PLANNING APPLICATIONS AND S106 OBLIGATIONS

Reference A. Planning Application 19/02550/F
B. Planning Obligations 21/03164/OBL

DRAWING SCALE: 1:125 @ A1	BICESTER HOTEL, GOLF & SPA	DRAWING NO: BICE.304
DRAWING SCALE: 1:250 @ A3		DRAWING REVISION: /
ORIGINALLY ISSUED: 17/08/2021		DRAWN BY: W.A.S.
REVISION ISSUED: /		CHECKED BY: H.A.J.S.

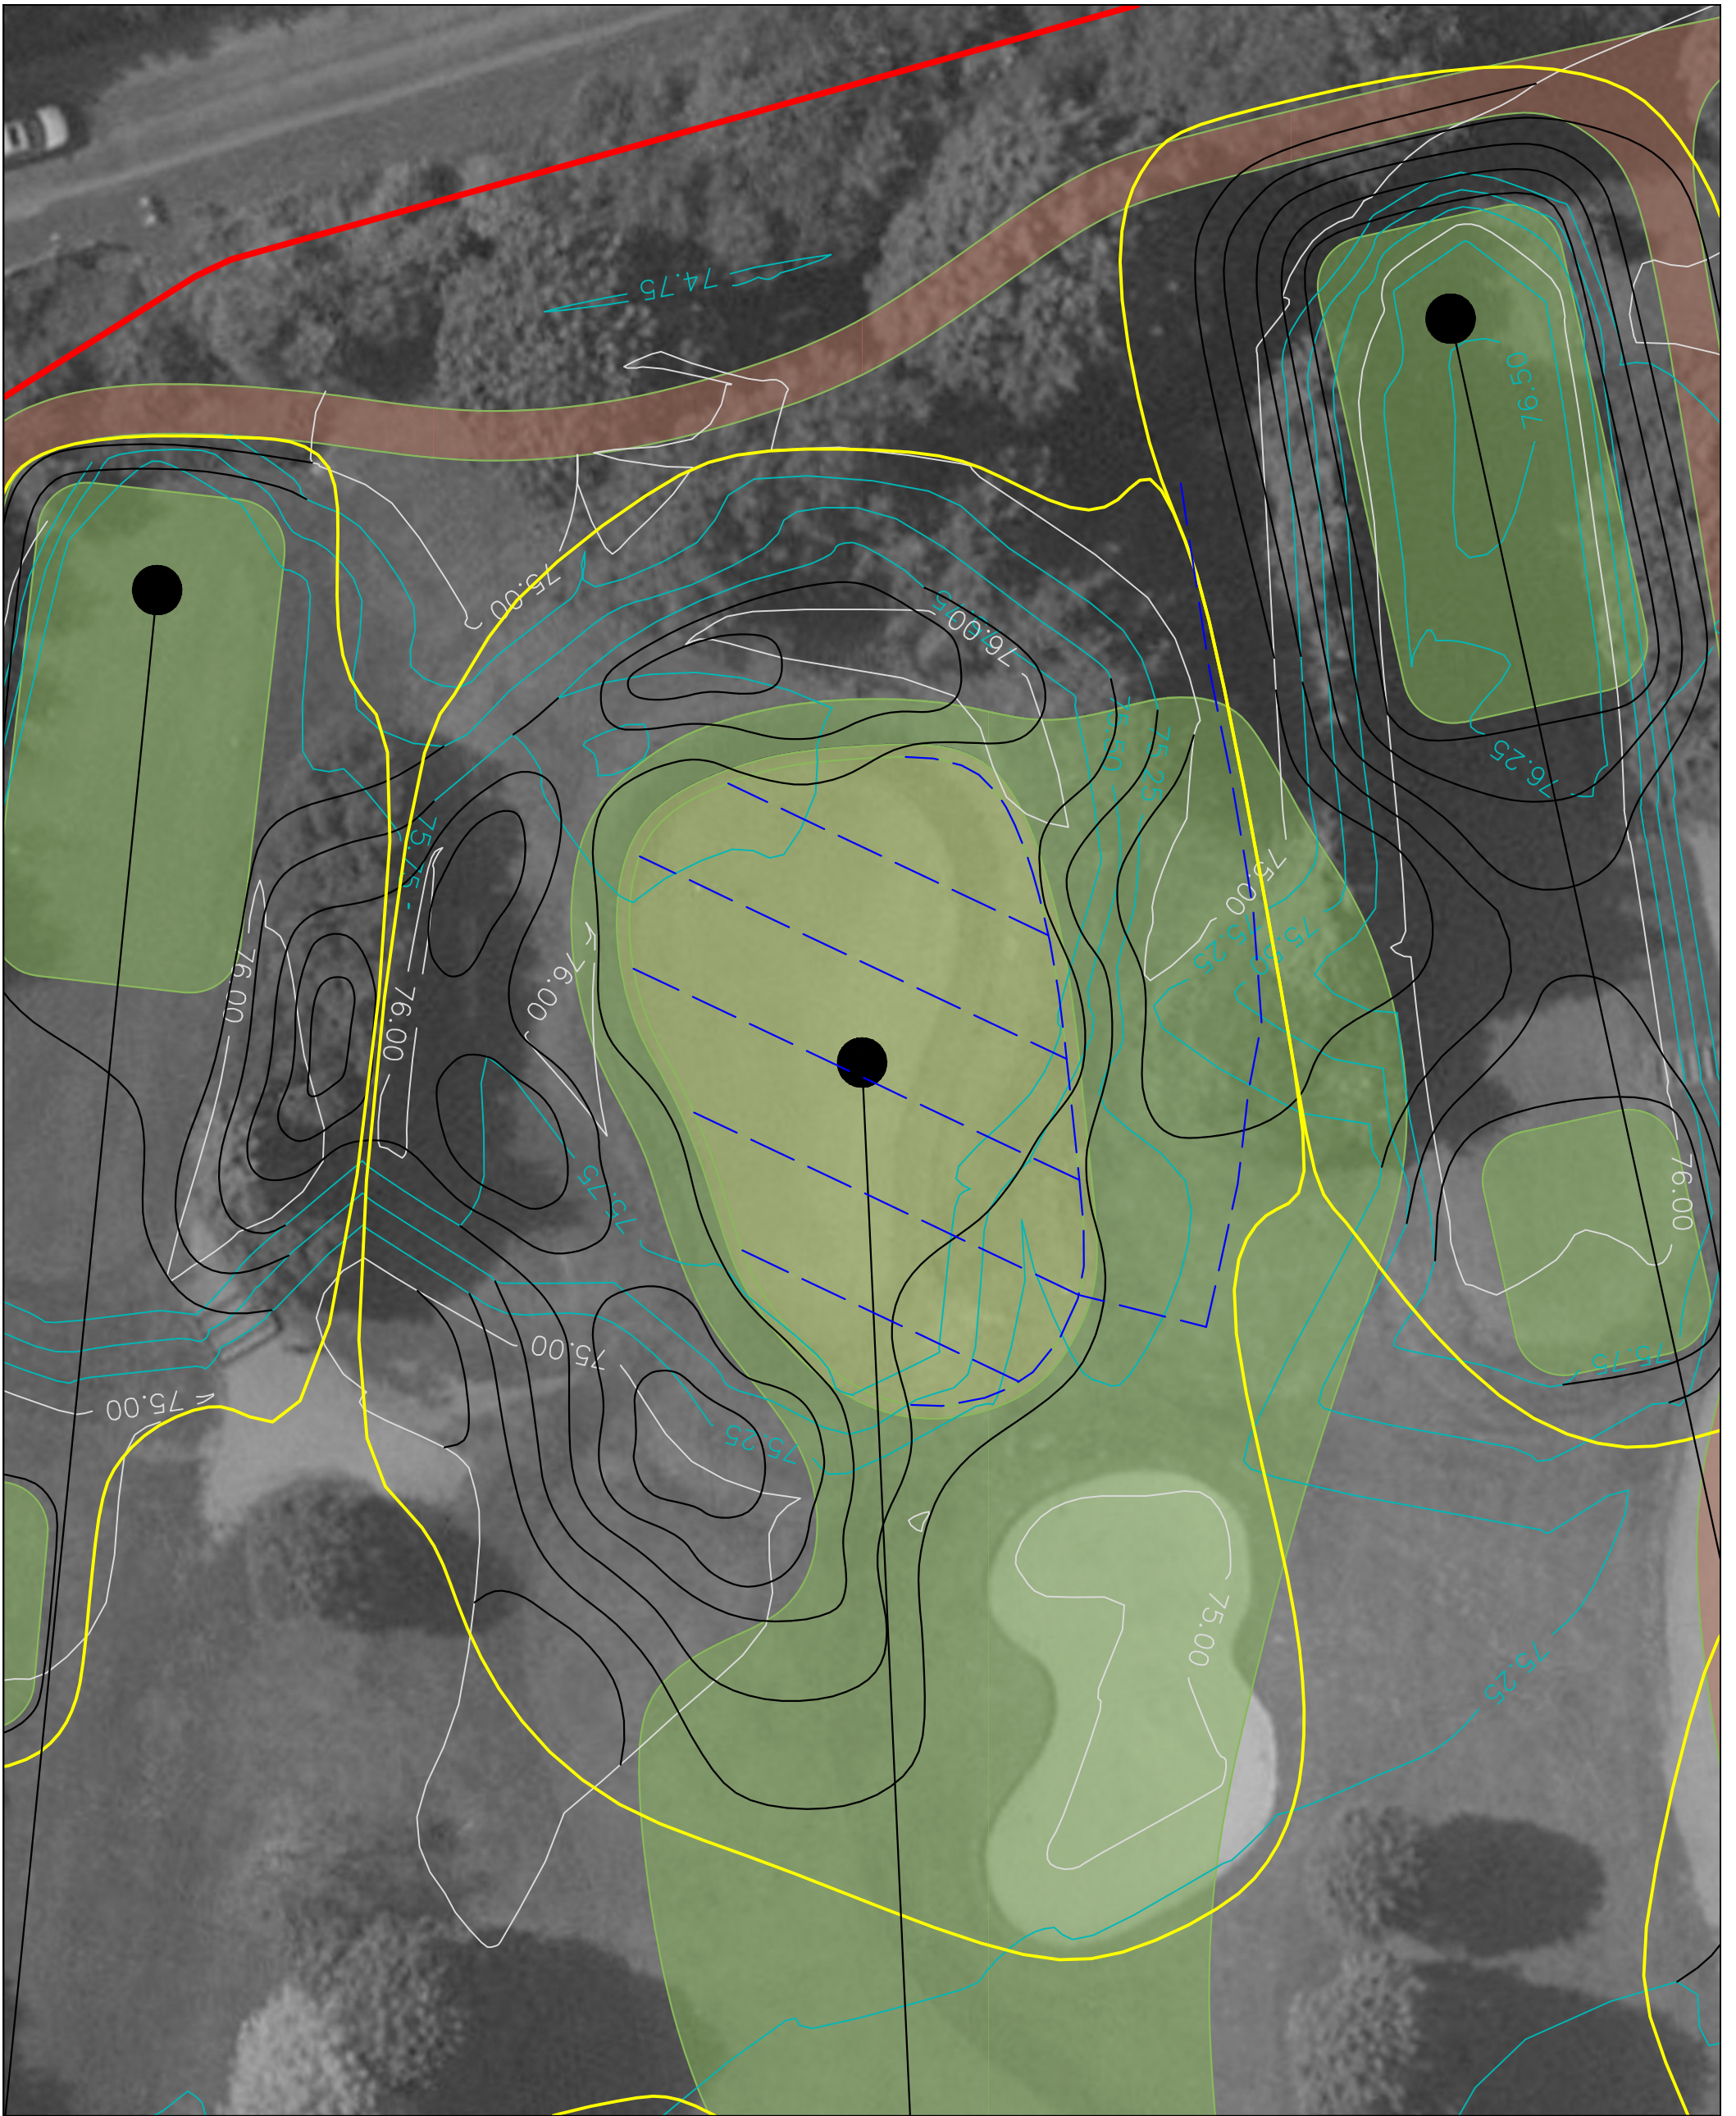
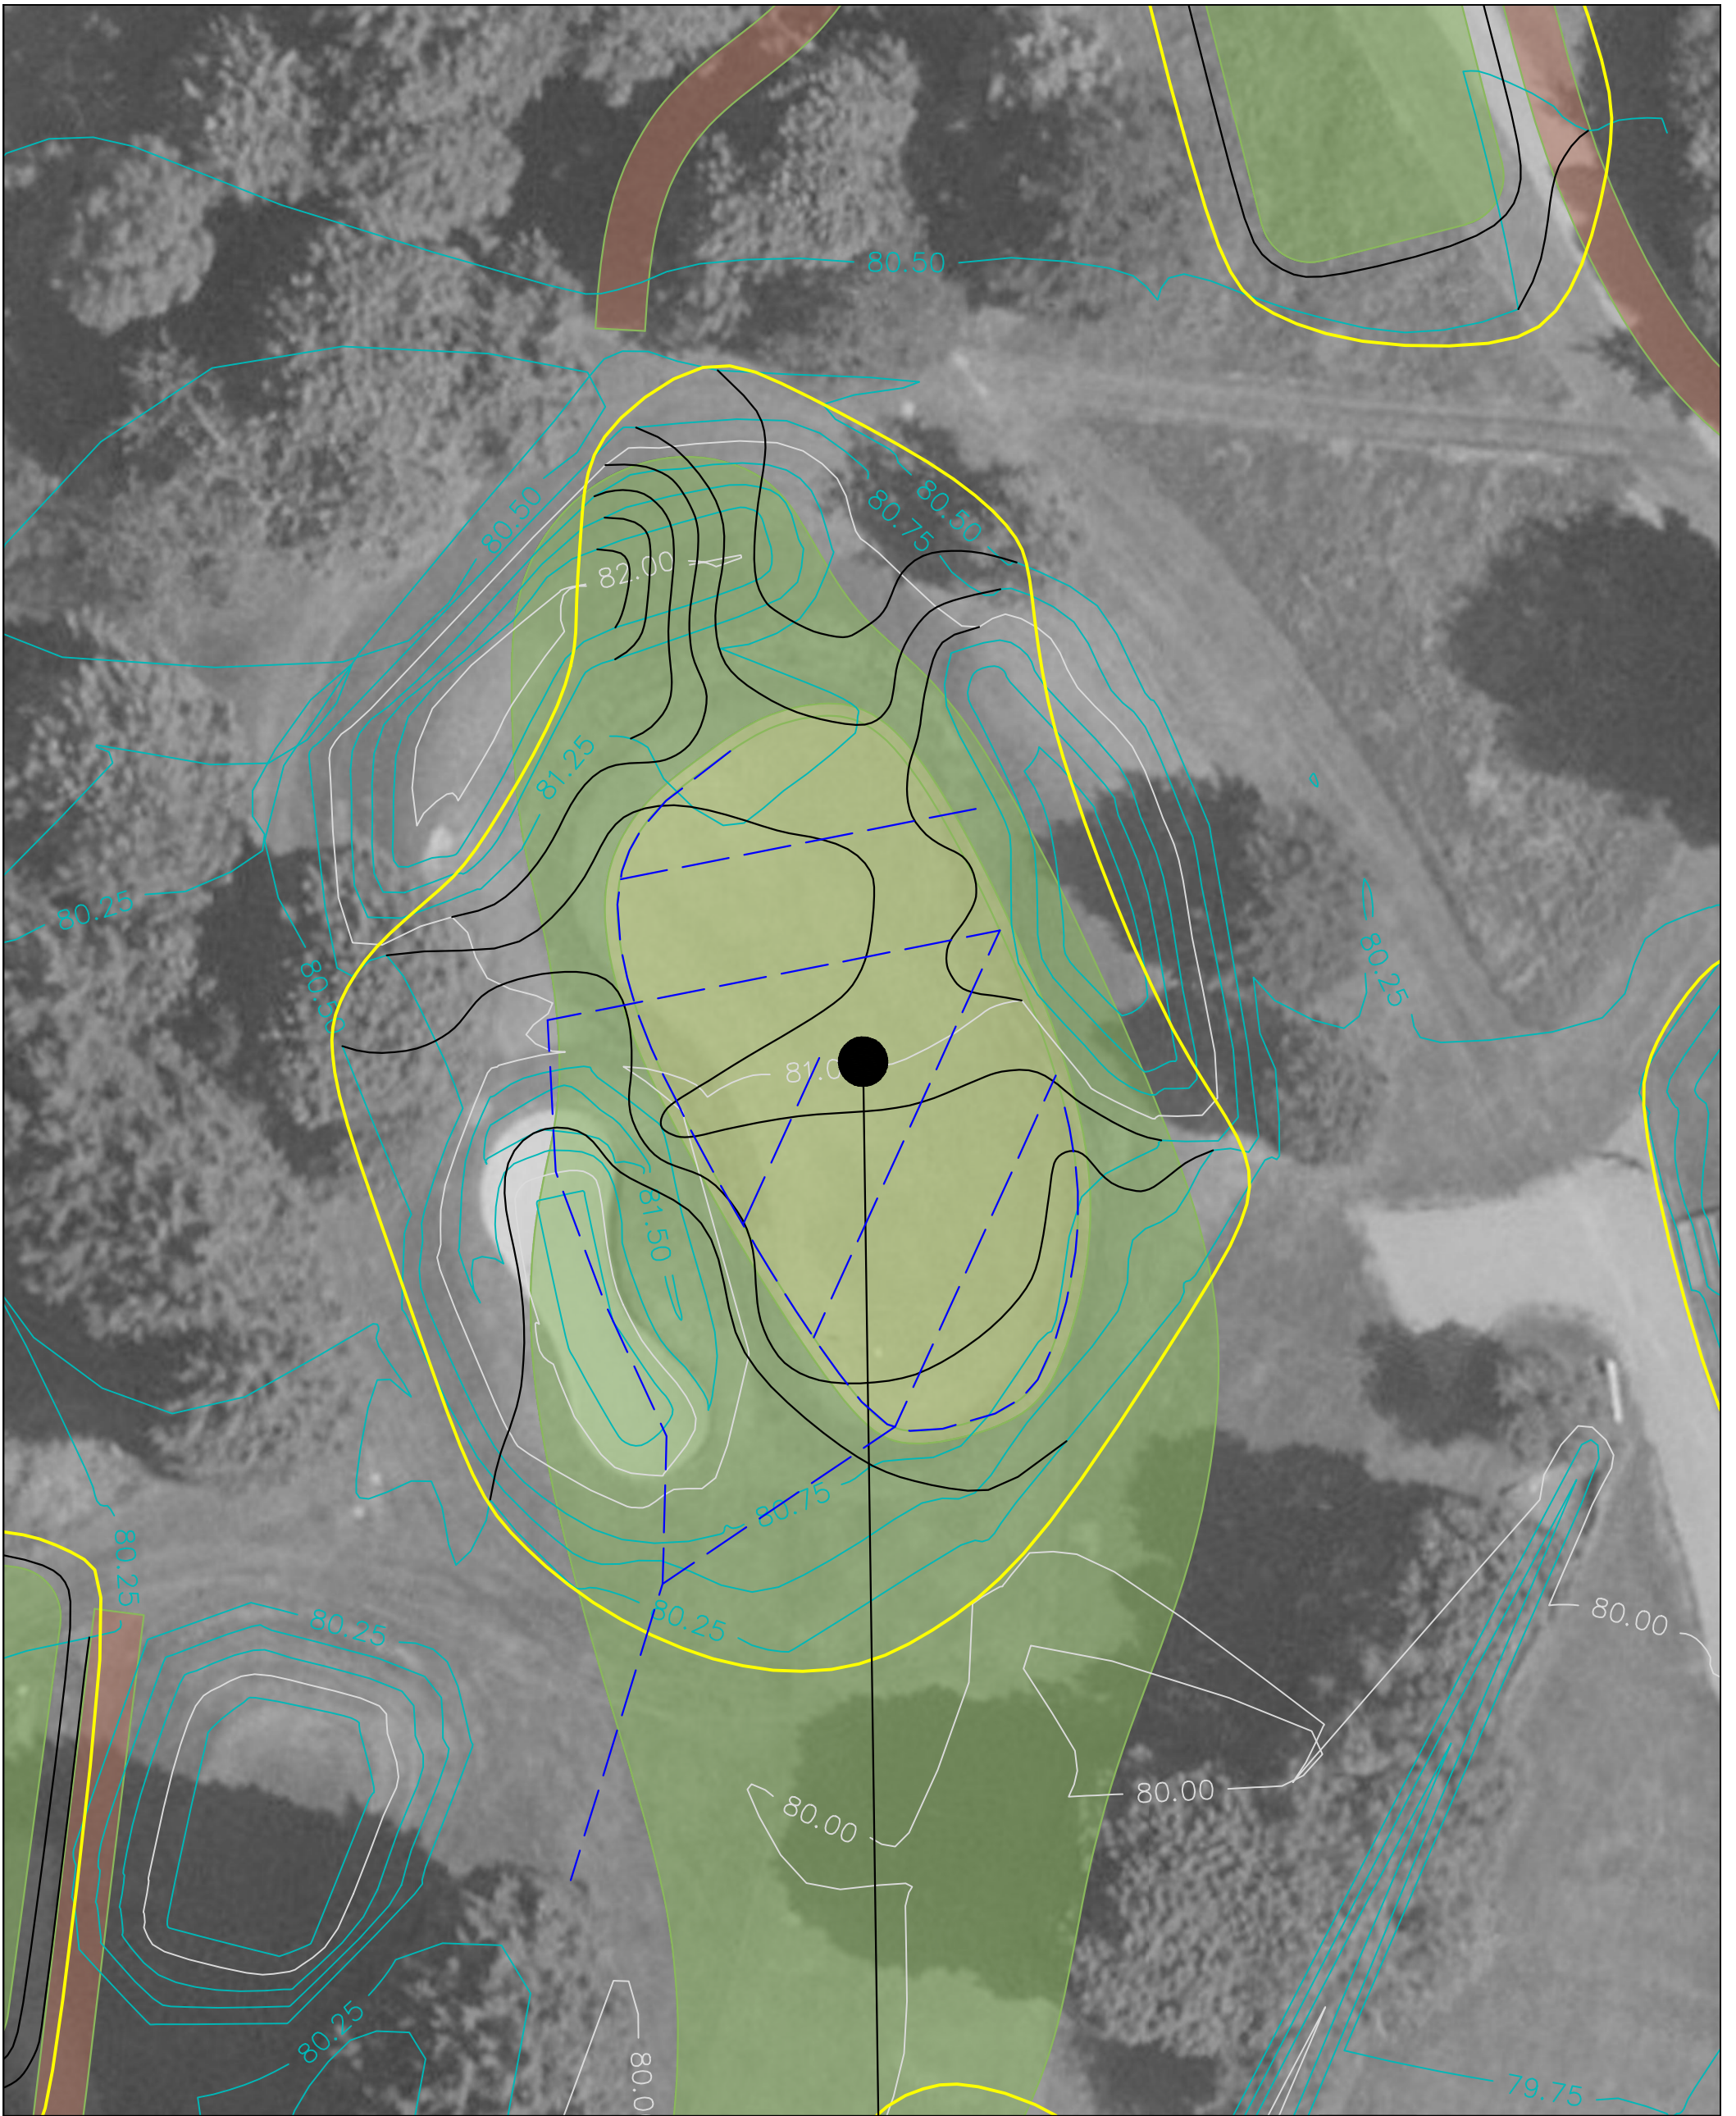
1. In particular they fail to properly address the matters of Health and Safety regarding the crossover points of golfers on the proposed new golf course layout. They do not provide any plan for the holes 10 to 18 where conflict when playing different circuits occurs. The only course plan provided is for holes 1 to 6. It seems their plan has not been submitted to Golf England for over-site and approval, yet the designer say it's an improved golfing facility. This is insufficient information for discharge to proceed.
